COMPULSORY ACQUISITION HEARING 1

ORAL PRESENTATION BY BEN MYERSCOUGH MRICS FAAV

BERWICK DOWN LTD & BIDDESSEN HOUSE FARM PARTNERSHIP

Drawing Title  
FIGURE 13.3A  
PROPOSED PUBLIC RIGHTS OF WAY

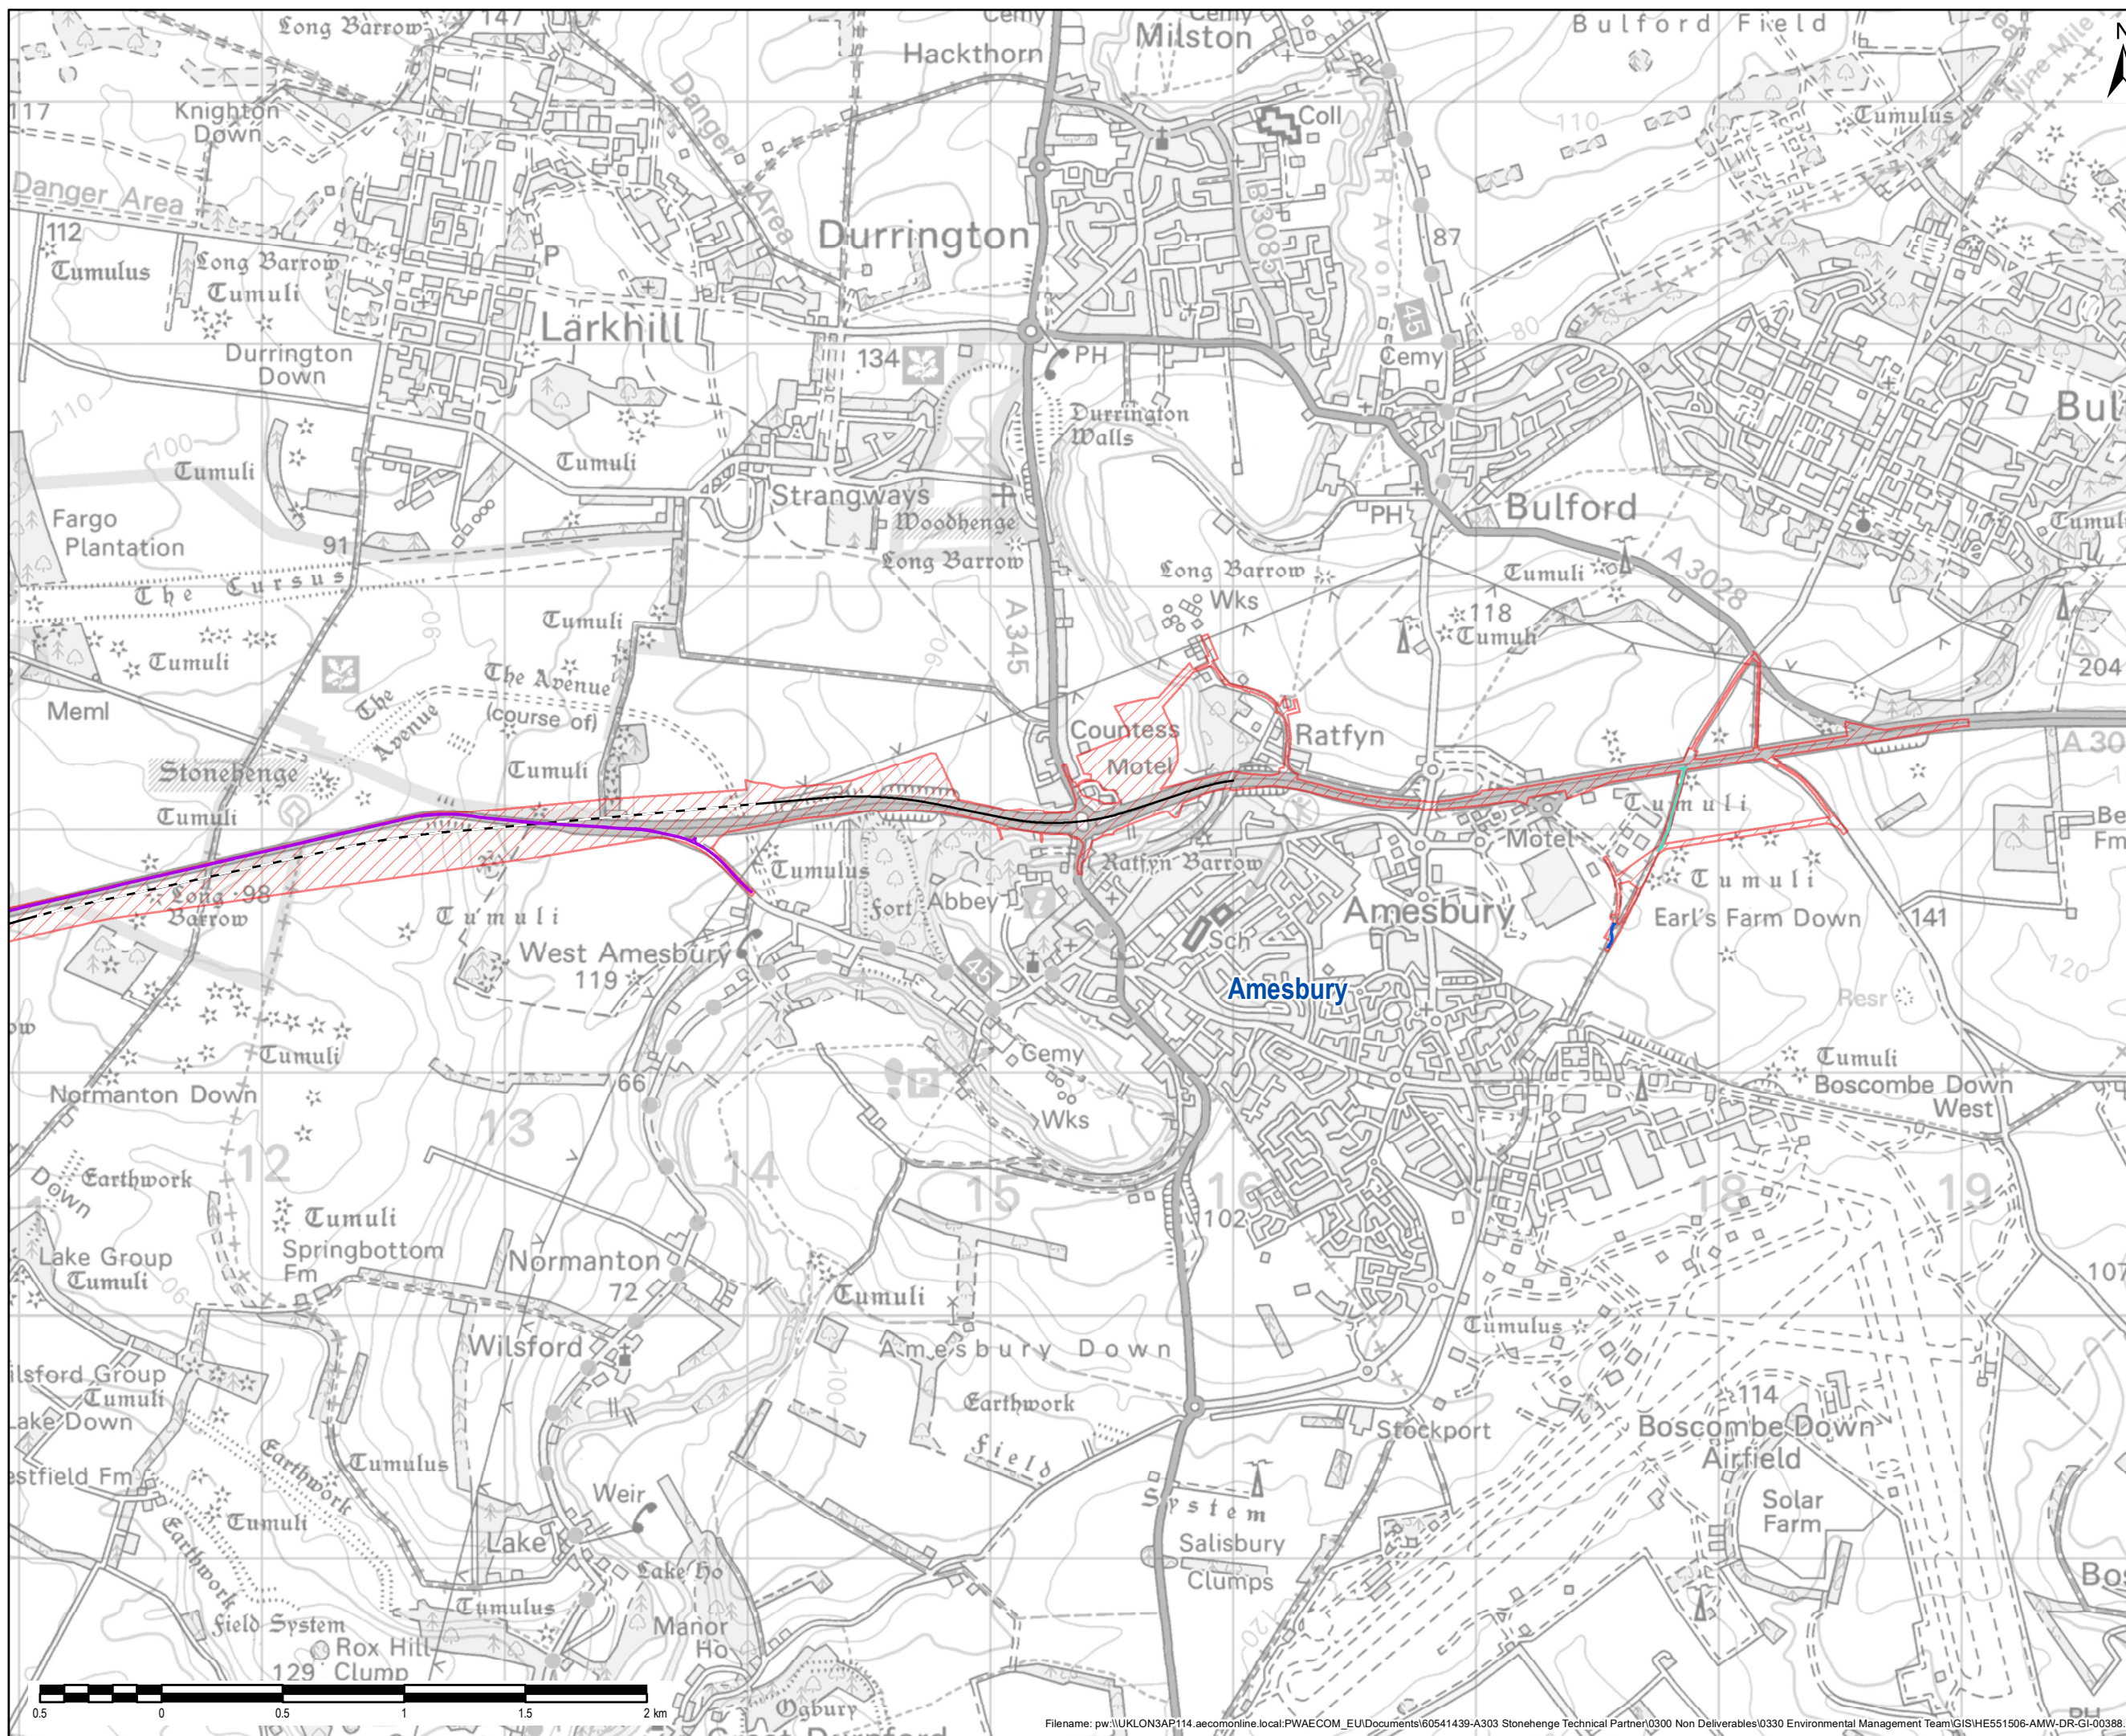
Further to this, we have questioned the justification of the position of and potential acquisition of rights for the new restricted byway running north/south from Longbarrow roundabout to connect to

BSJA11 (A360 – A303). In its current form the new PRoW will result in the formation of a small triangular field west of the new byway which, due to its shape, will be impractical to farm commercially. We have therefore requested that consideration be given to diverting the new way so that it runs south of the new A303 along the route of the proposed cycleway to the newly formed junction and then in a south easterly direction to run parallel with the realigned A360.
